Shada Hasan
Oxfordshire County Council,
County Hall,
New Road,
Oxford,
OX1 1ND

Proposal Outline planning application for the construction of up to 140,000 sqm of employment floorspace (use class B8) with ancillary offices and facilities and servicing and infrastructure including new site accesses. Internal roads and footpaths, landscaping including earthworks to create development platforms and bunds, drainage features and other associated works including demolition of the existing farmhouse.

Location Land east of Junction J.11, M40, Banbury

Application No. 23/03428/OUT

Drawing
**Conceptual Drainage Sketch
Catchment B Area**

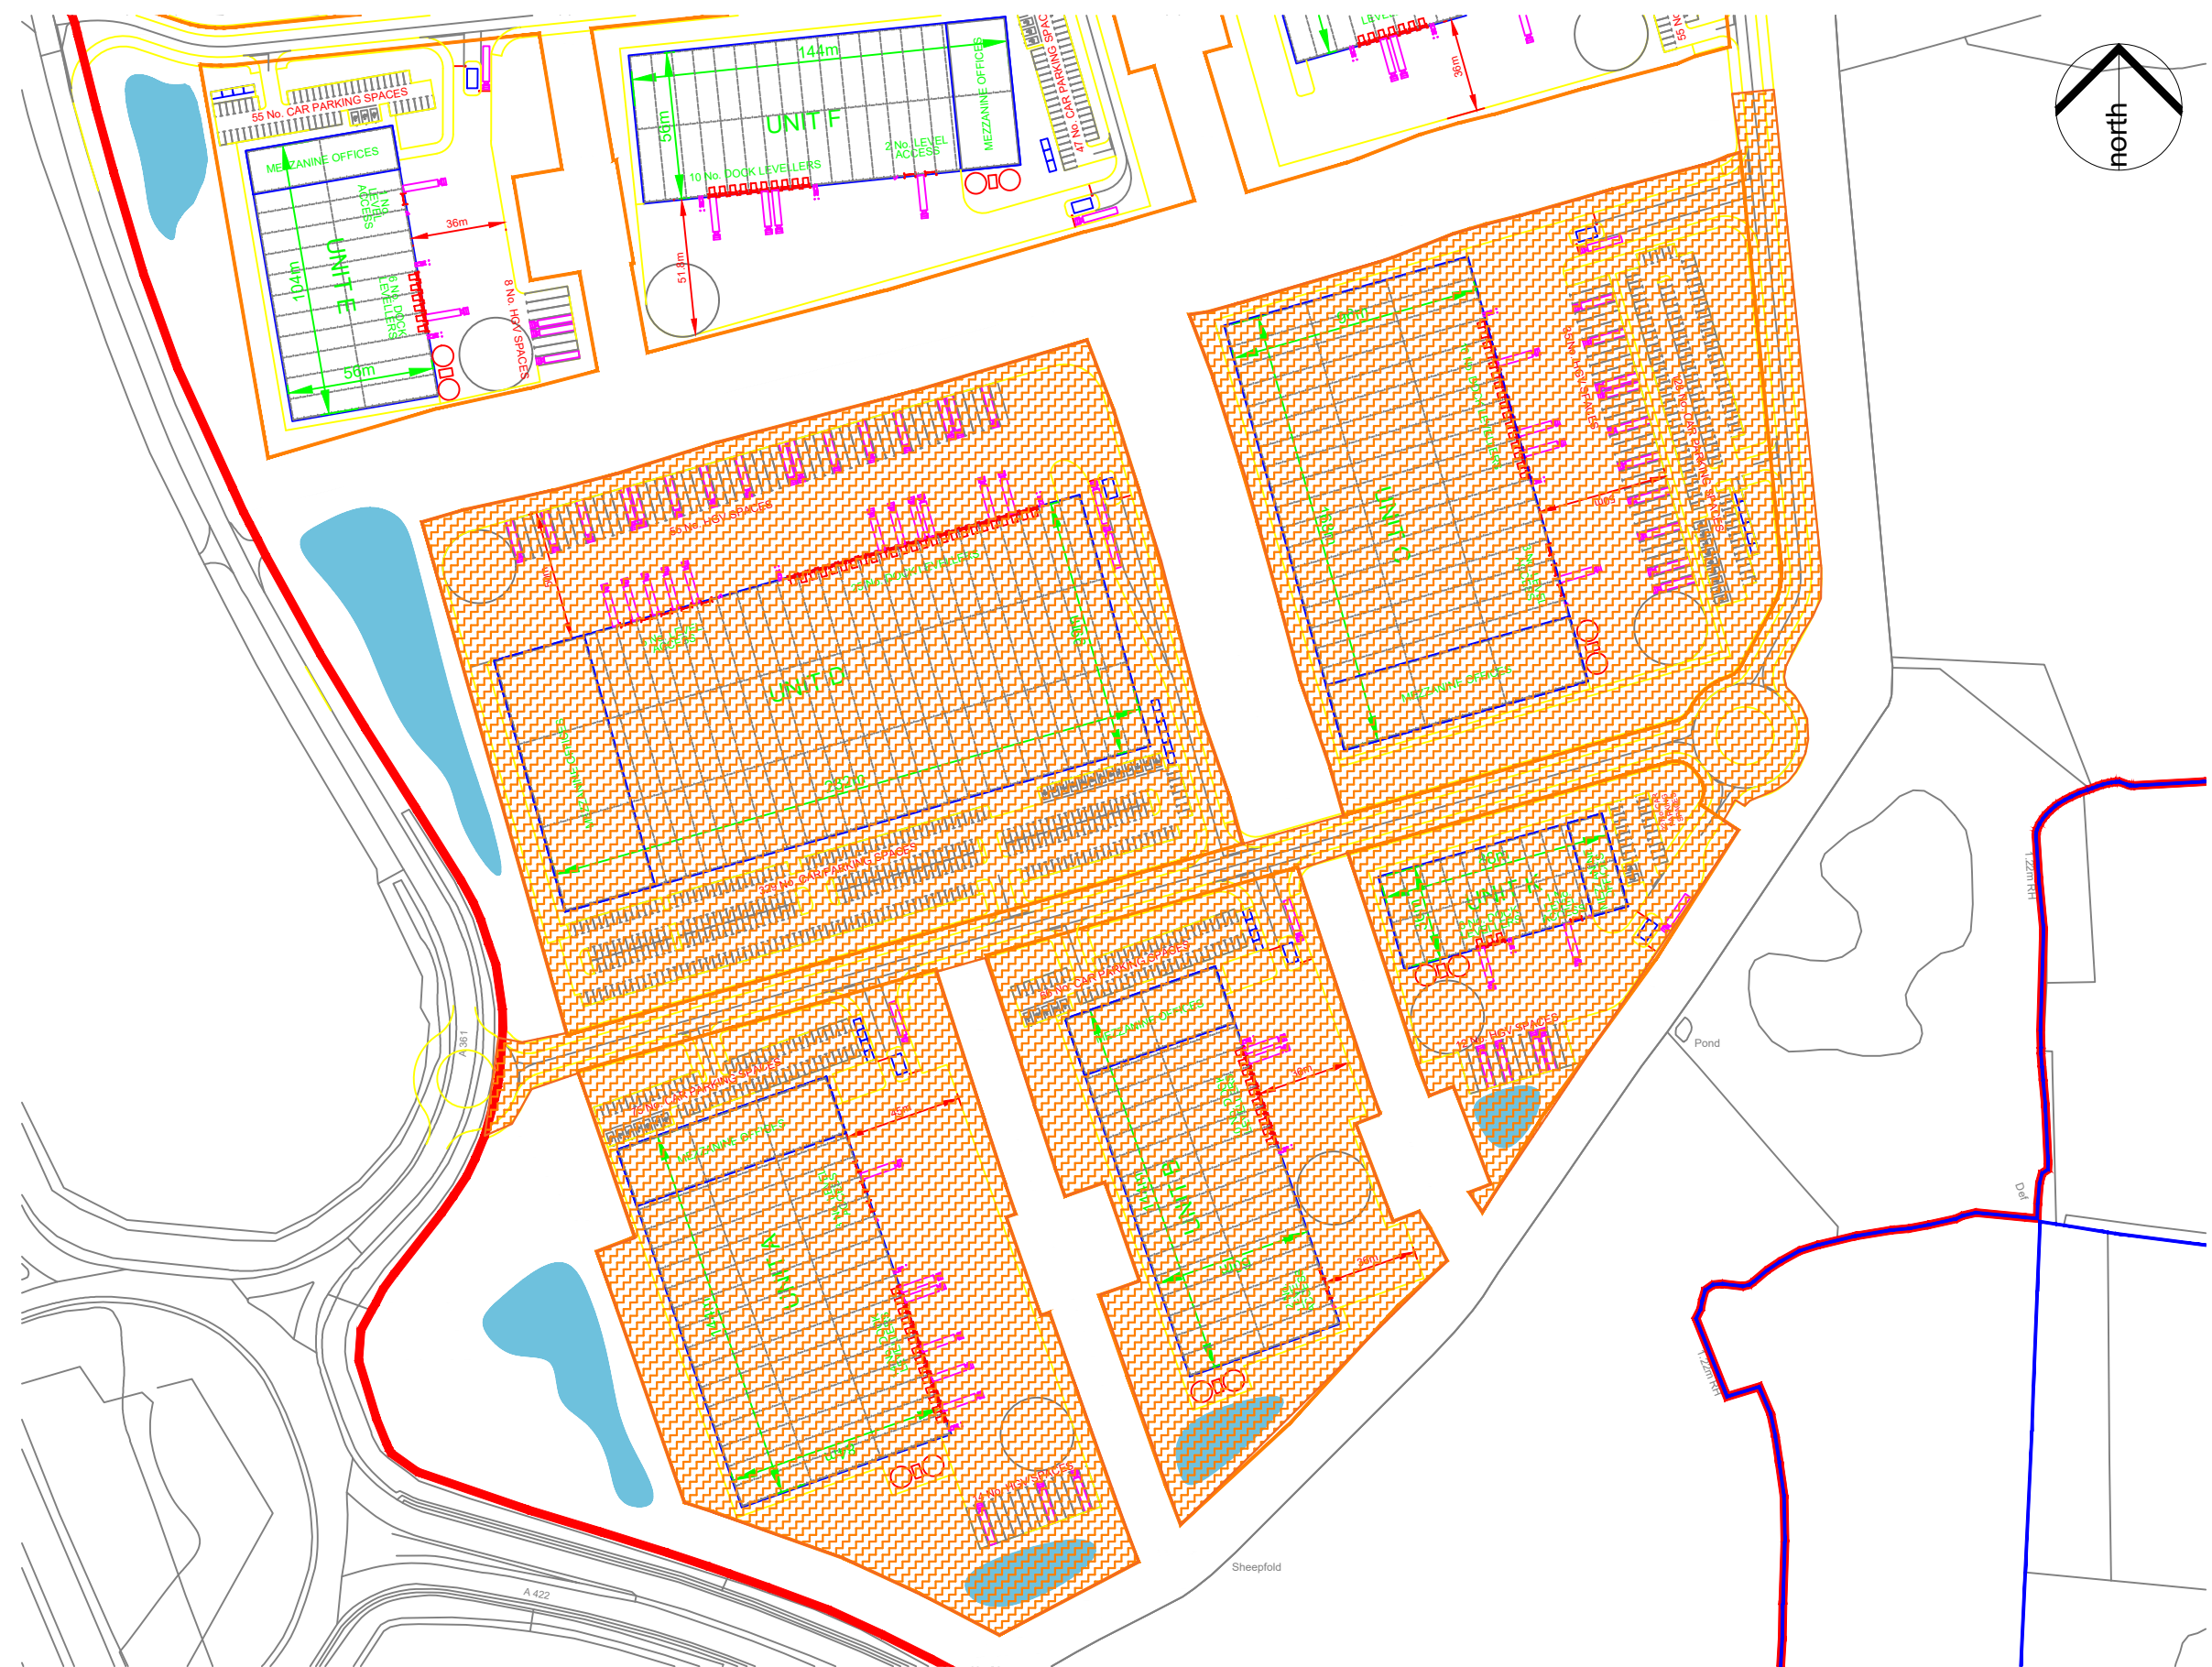
“The catchment areas have been broken down in the FRA, however a Catchment plan is required to highlight the extent of the areas. Stating the total impermeable area and the impermeable area including urban creep”.

A Catchment Plan is included in Appendix B of this letter.

The site can be split into two catchments each served by the two existing culverts at the lowest extents of the site. The site can be further split into individual plot catchments at the detailed design stage if required. It is reiterated that the layout is not fixed, and the catchment areas may change as a result of works undertaken at the detailed stage.

Area (m ²)	Discharge Rate (l/s)
Catchment A	143,060	206.9
Catchment B	175,287	253.56
